Application Ref:	2025/0860				Ribble Valley Borough Council www.ribblevalley.gov.uk	
Date Inspected:	P/A	Site Notice:	N/A			
Officer:	SK					
DELEGATED ITEM FILE REPORT:					APPROVAL

Development Description:	Proposed replacement dwelling (self-build).
Site Address/Location:	Kemple Down Birdy Brow Chaigley BB7 3LR

PL.20

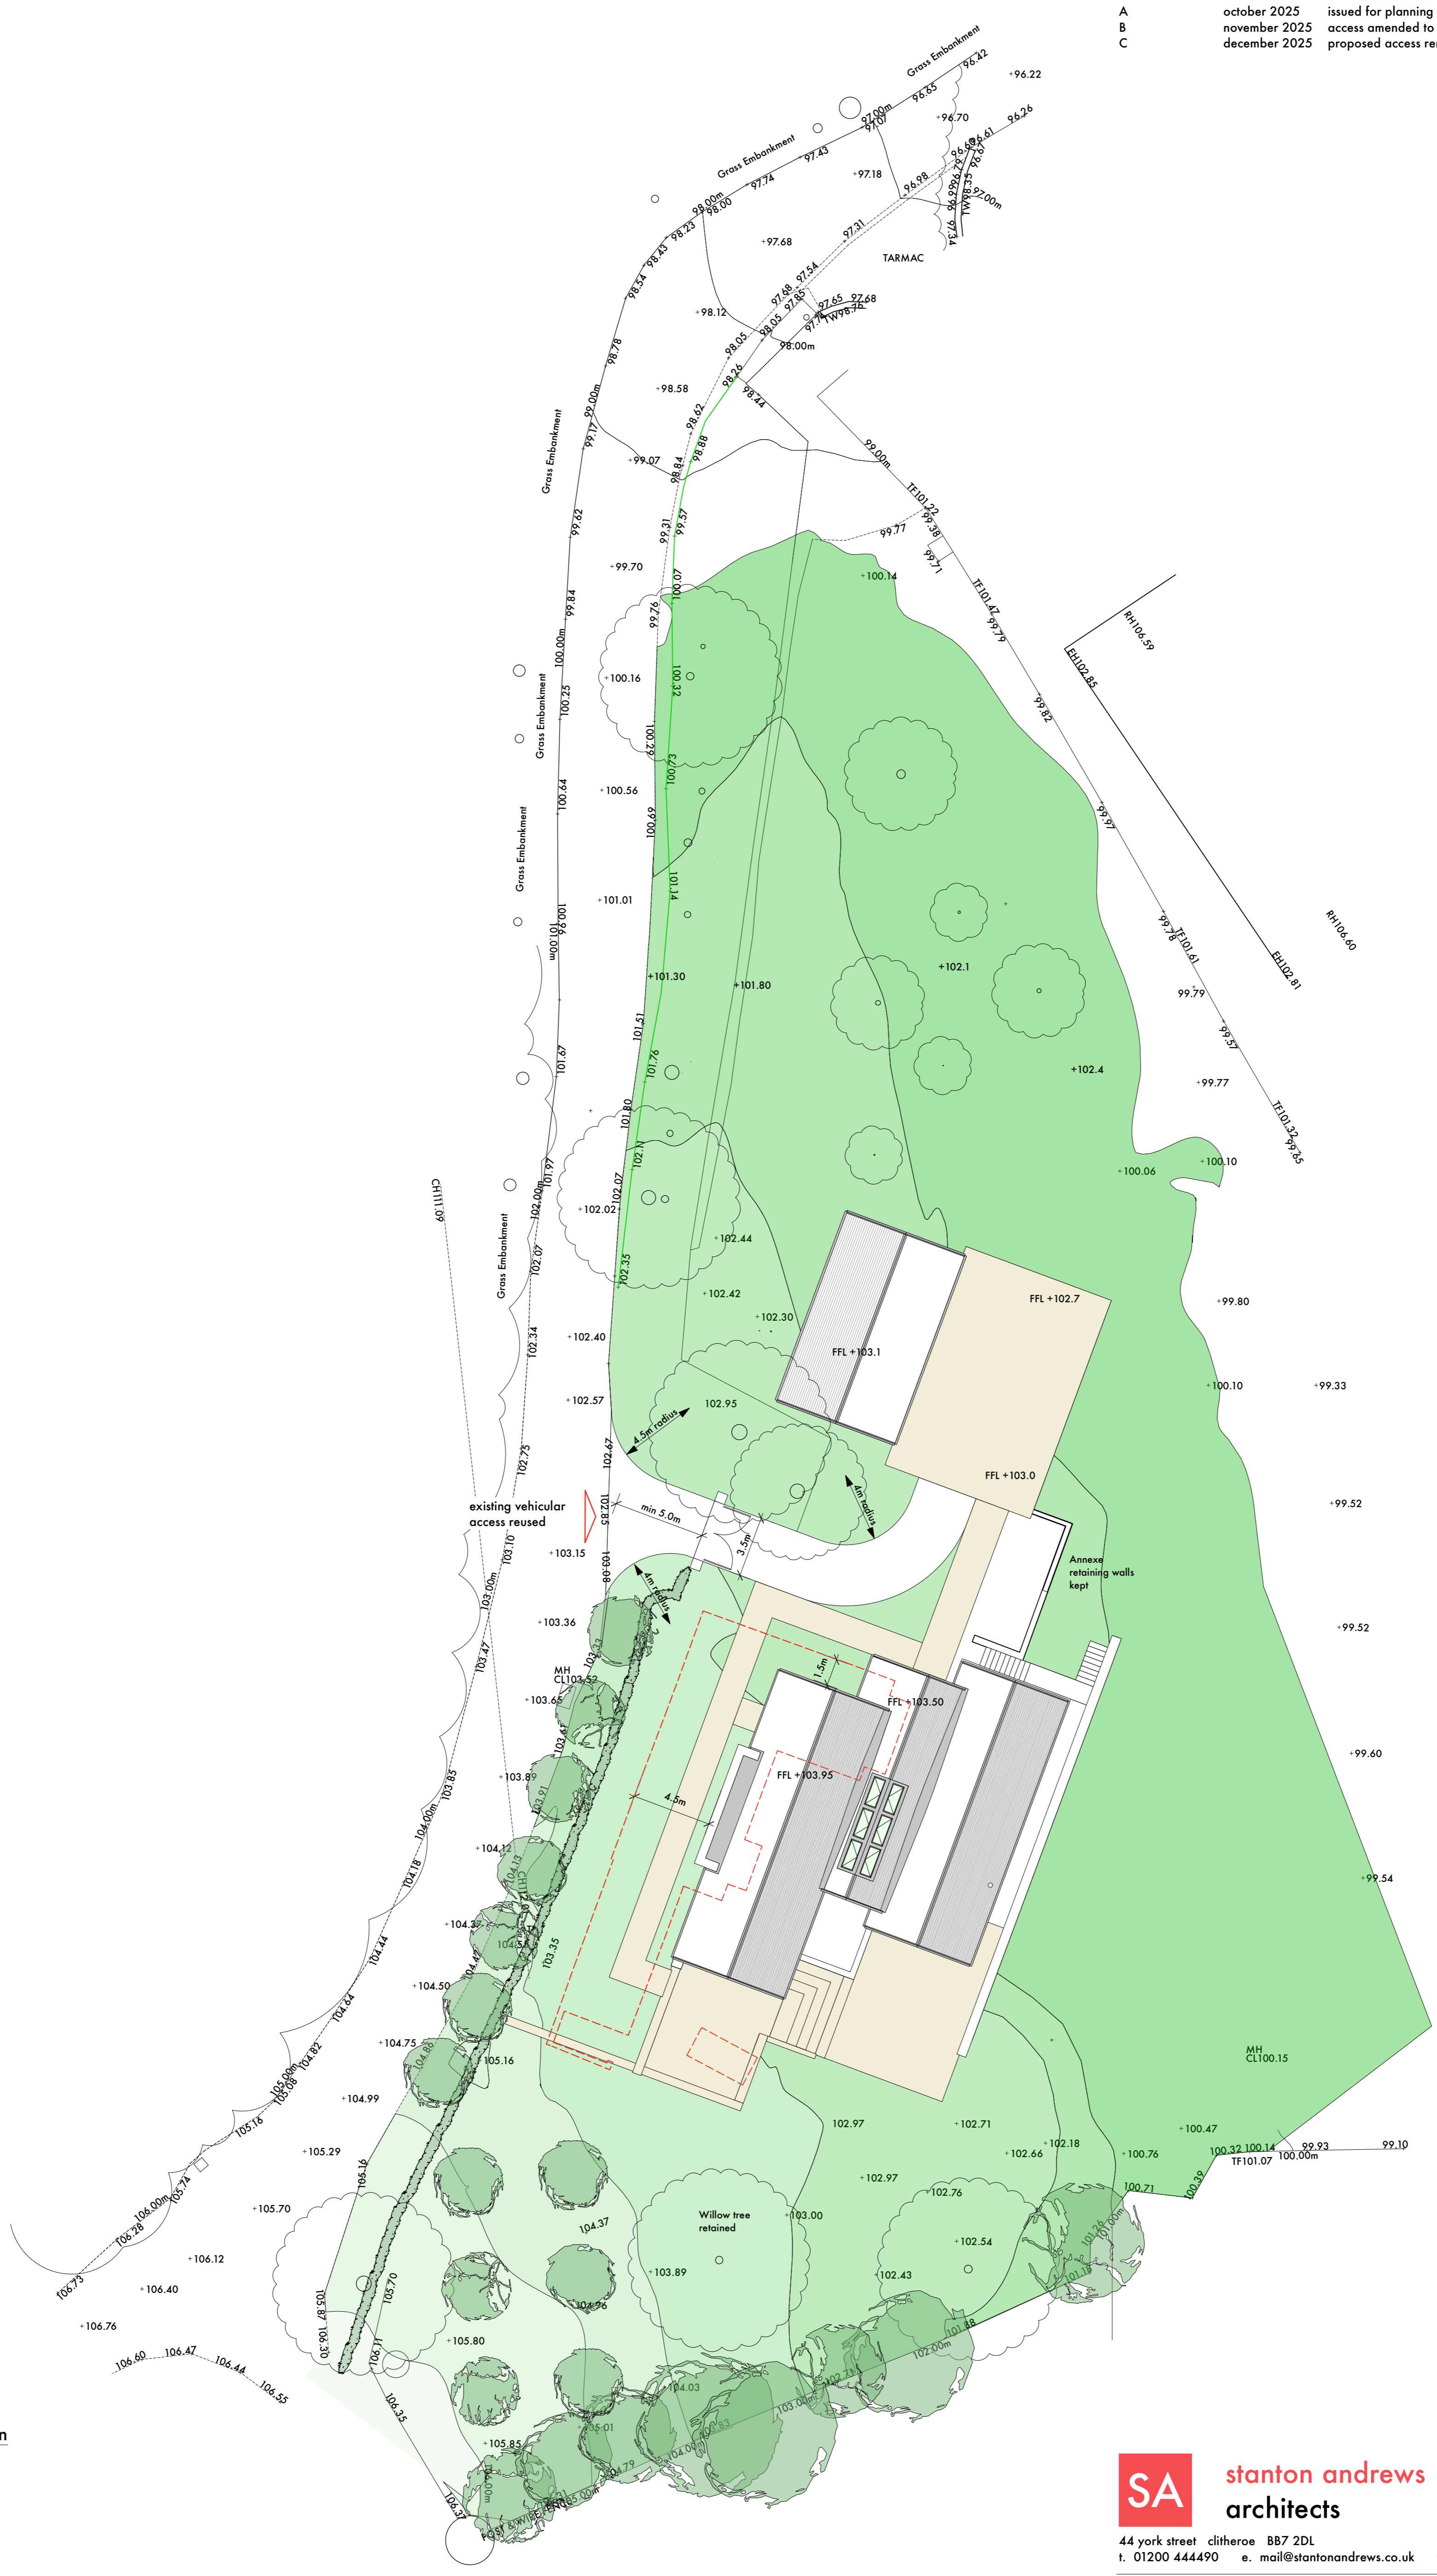
CONSULTATIONS:	Highways/Water Authority/Other Bodies
LCC Highways:	
Object to the proposed northern access and request it is omitted from the plans. The southern access can achieve acceptable visibility and is situated in an acceptable location.	
CONSULTATIONS:	Additional Representations.
No representations received in respect of the proposed development.

The application seeks consent for the demolition of the existing dwelling and associated garage and the erection of a replacement dwelling and detached triple-garage. The submitted details further propose variations to the existing vehicular access point. The original submission also proposed an additional vehicular access point north of the existing access to facilitate a one-way 'entrance only and exit only' access configuration, although this has been omitted from the scheme due to concerns raised by the LHA.

On the basis that the northern access point has been omitted from the scheme, the LHA raise no objection to the proposal.

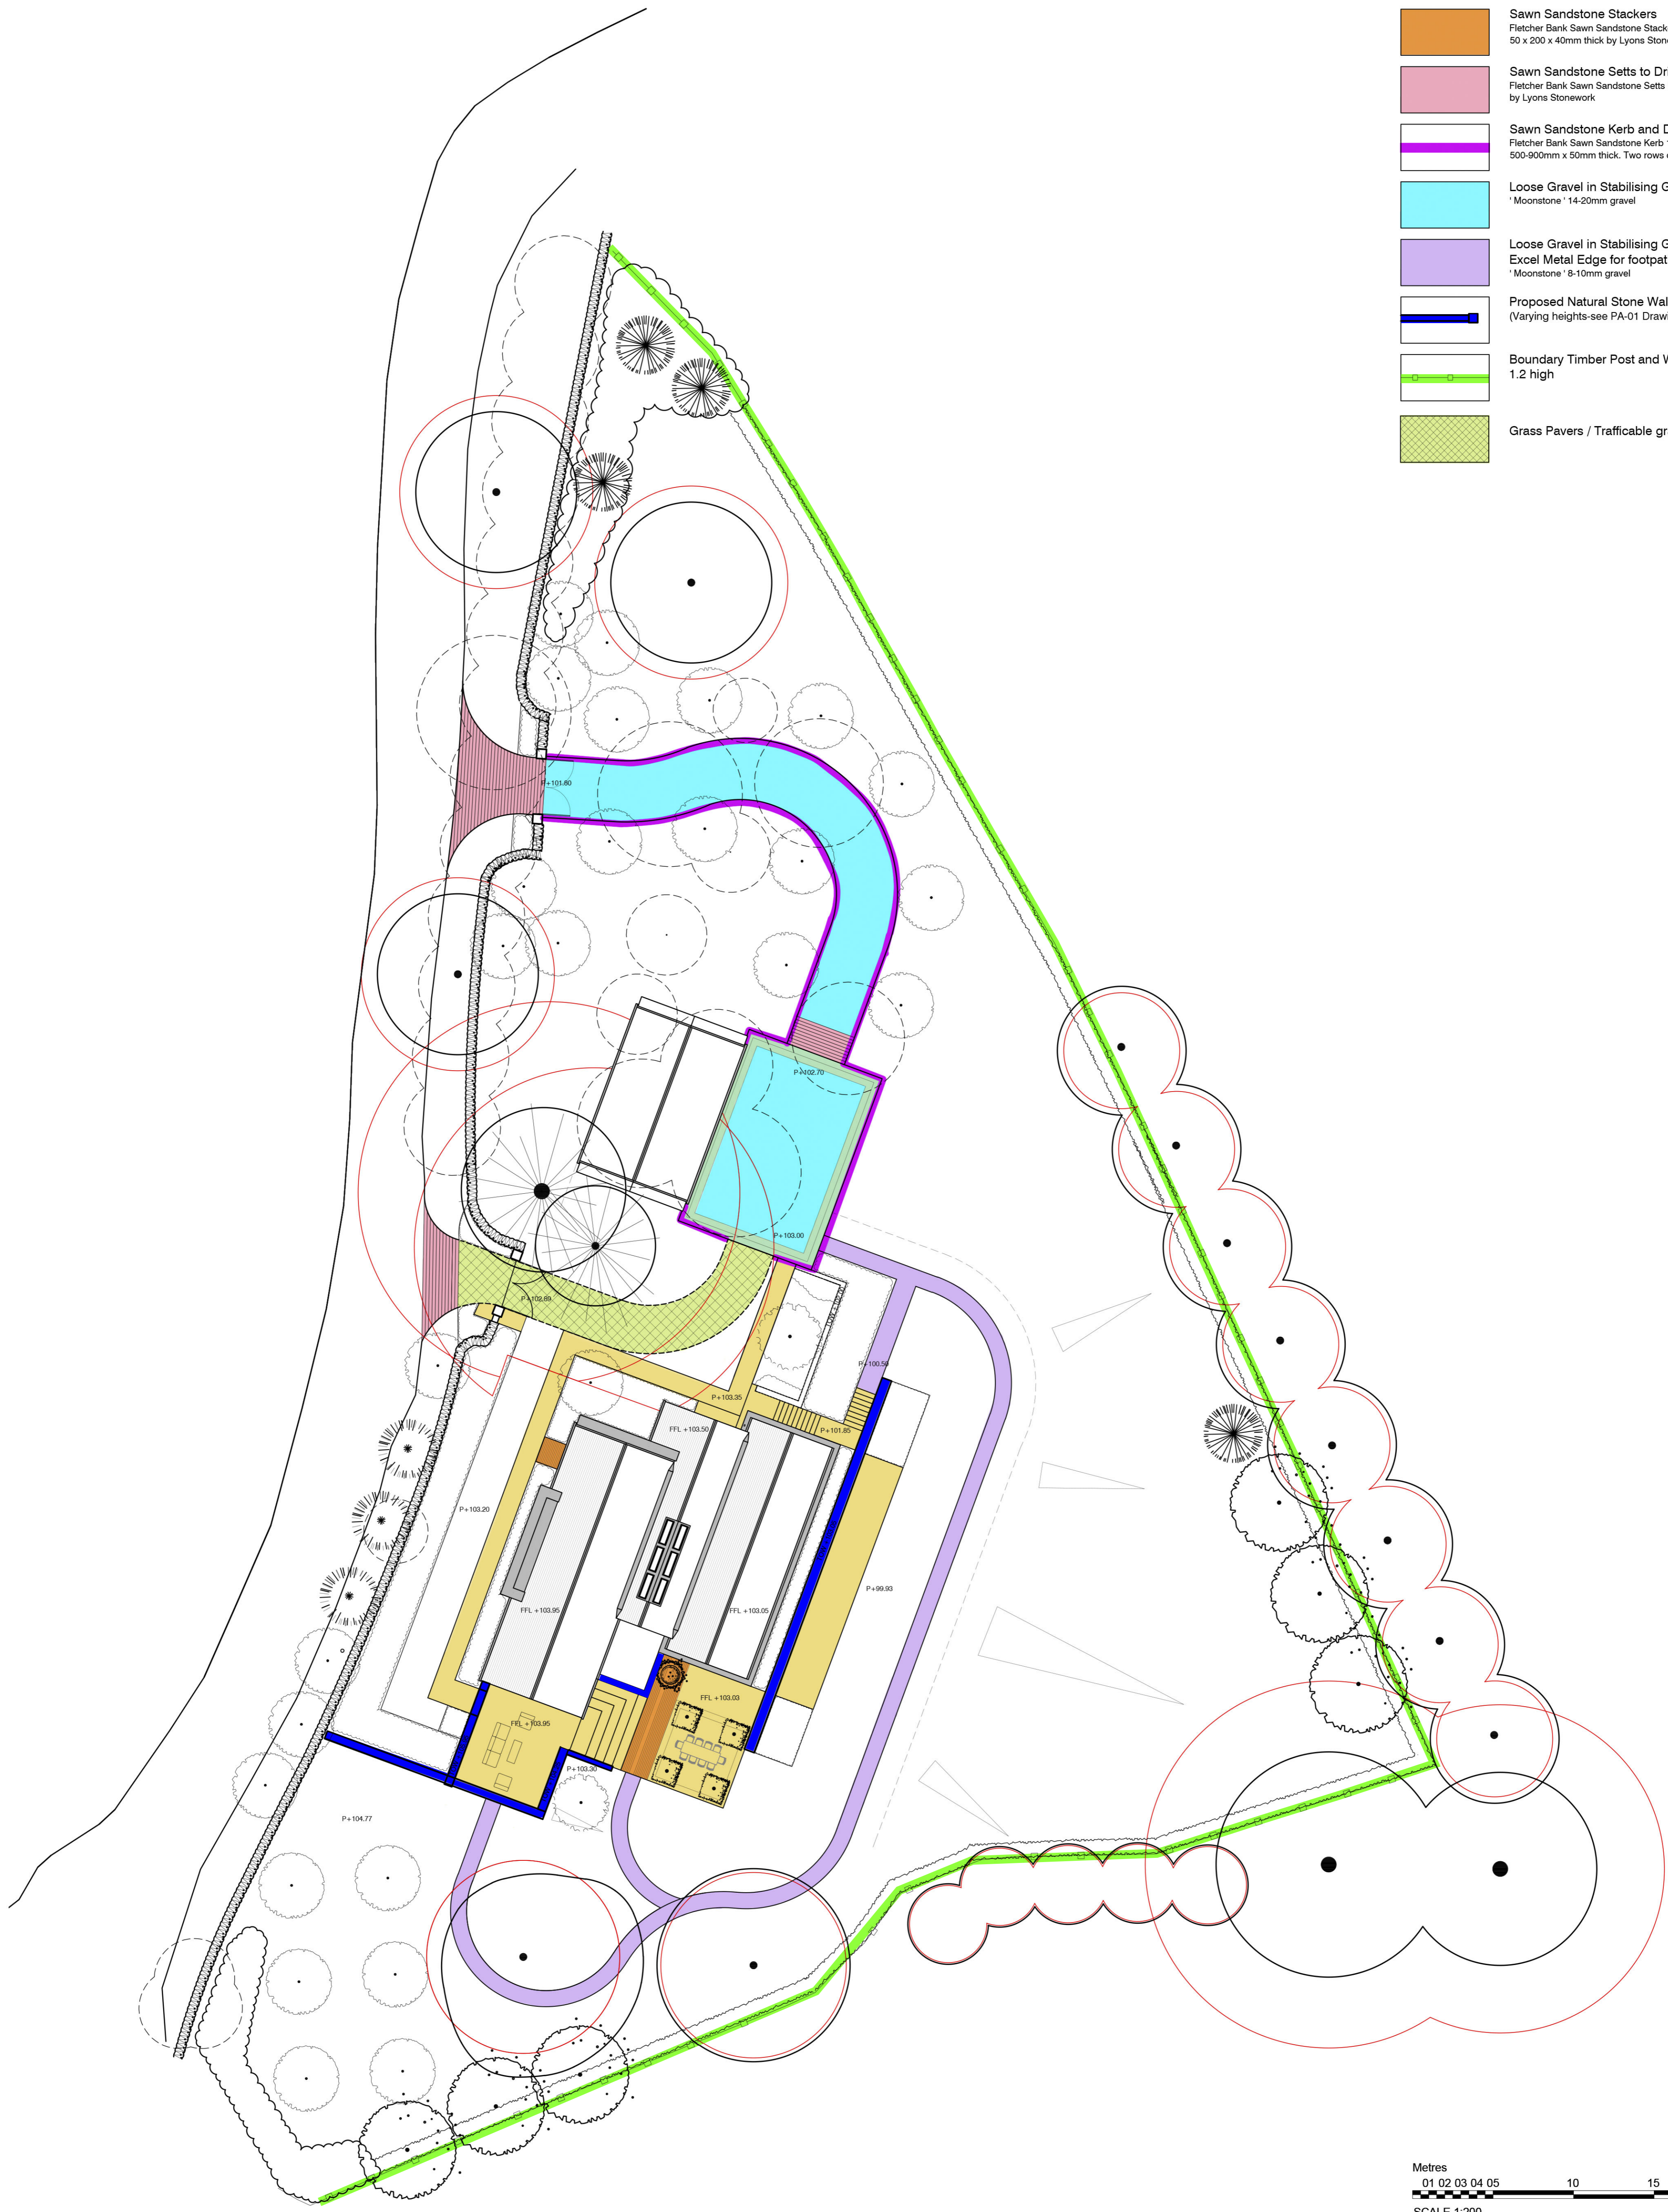
In relation to identified impacts upon existing trees and/or hedgerow, the original submission proposed the removal of a significant number of trees to facilitate the new access, however as this new access has since been omitted, updated landscape plans have been submitted showing the retention of these trees save for the following:-

- **T7 Cypress (Category C):**
Remove in order to relandscape
- **G3 Orchard (Category C):**
Remove in part in order to construct new garage
- **G7 3no. Ash, Hazel (Category U):**
Remove in order to relandscape

The application has been accompanied by a comprehensive hard and soft landscaping proposal that proposes the planting of new trees, native hedge mix and ornamental shrubs, which will mitigate for any tree removal.
